The Member-Secretary,
Madras Metropolitan
Development Authority,
8, Gandhi-Irwin Road,
Madras: 600 008.

The Management Officer,
British Deputy High Commission,
24, Anderson Road,
Madras - 600 006.

Letter No. C 4/15328/95

Sub: MMDA - Planning Permission - Construction
of Grand House at Door No 24, ^{Additional} building Anderson Road,
Madras - 6, R.S.N. 84, Block N-15, Nungambalam
- bakkam, madras -
Development Charges and Other charges to
be remitted - Regarding.

SITE PLAN. (SCALE: 1/32" = 1'-0")

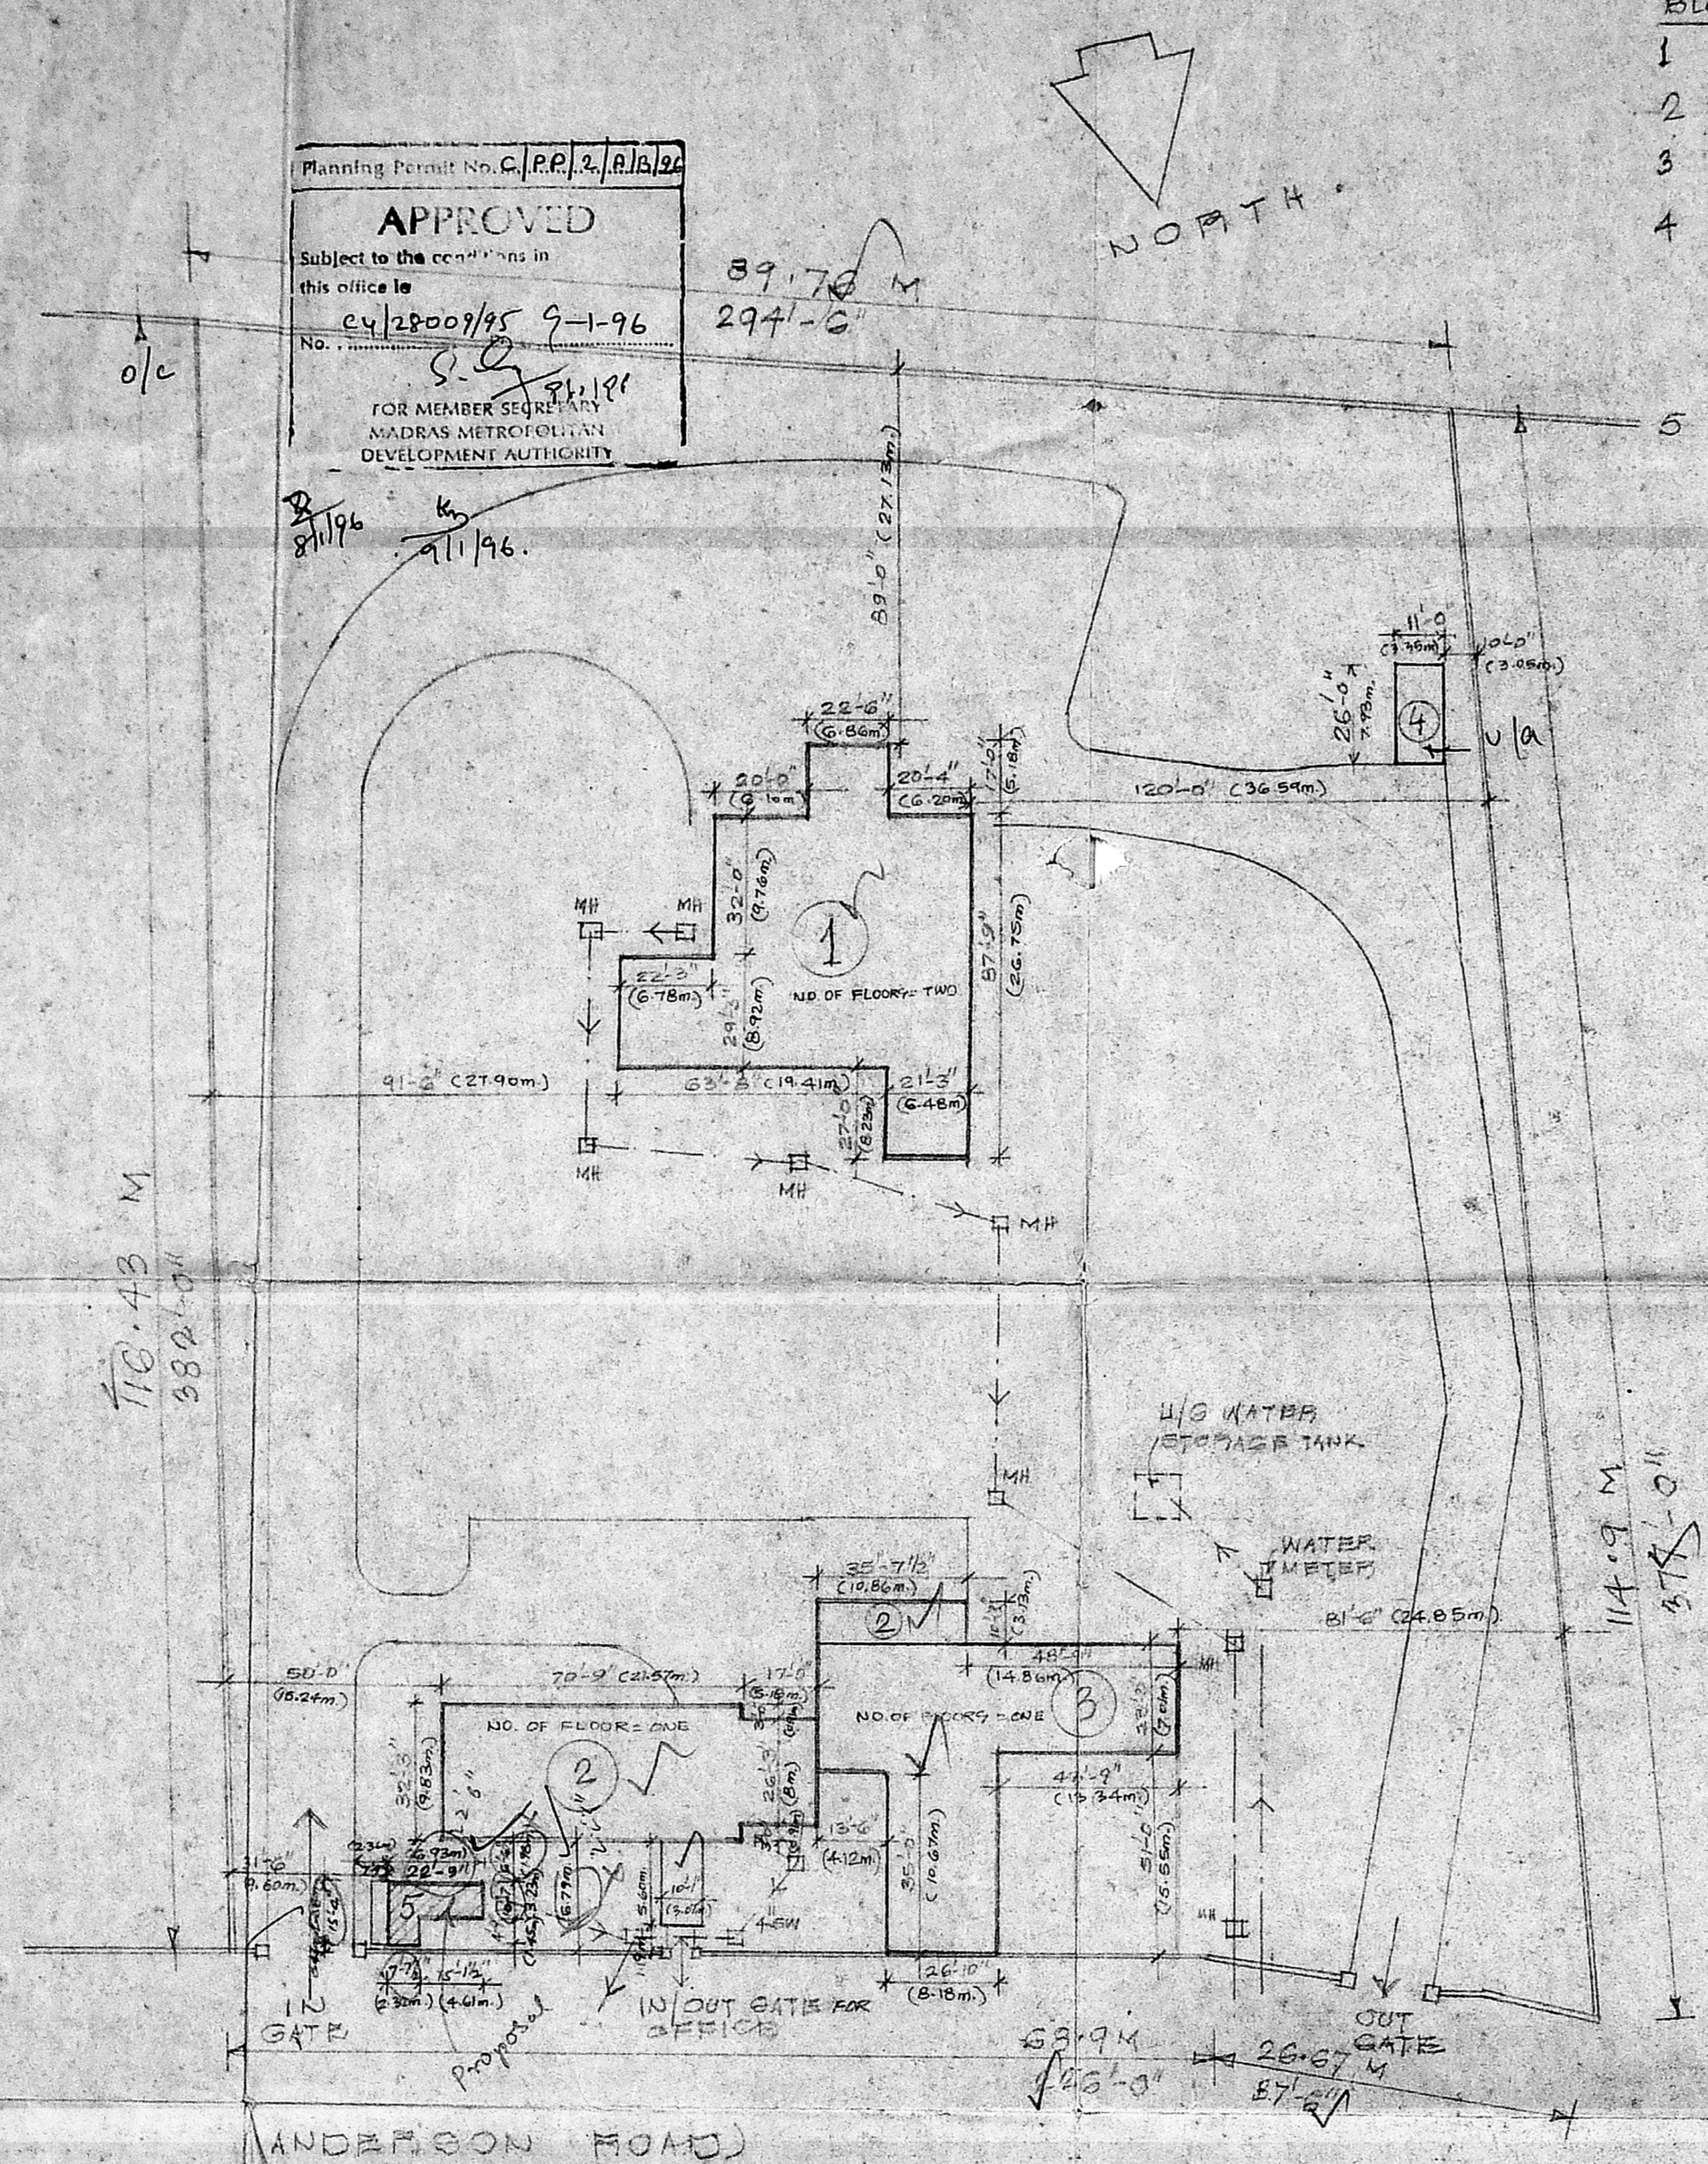
d, Revised ~~plan~~ site plan showing the set backs measurements reflecting

* the overall ~~building~~ measurements of the proposed building tallying with the detailed plan.
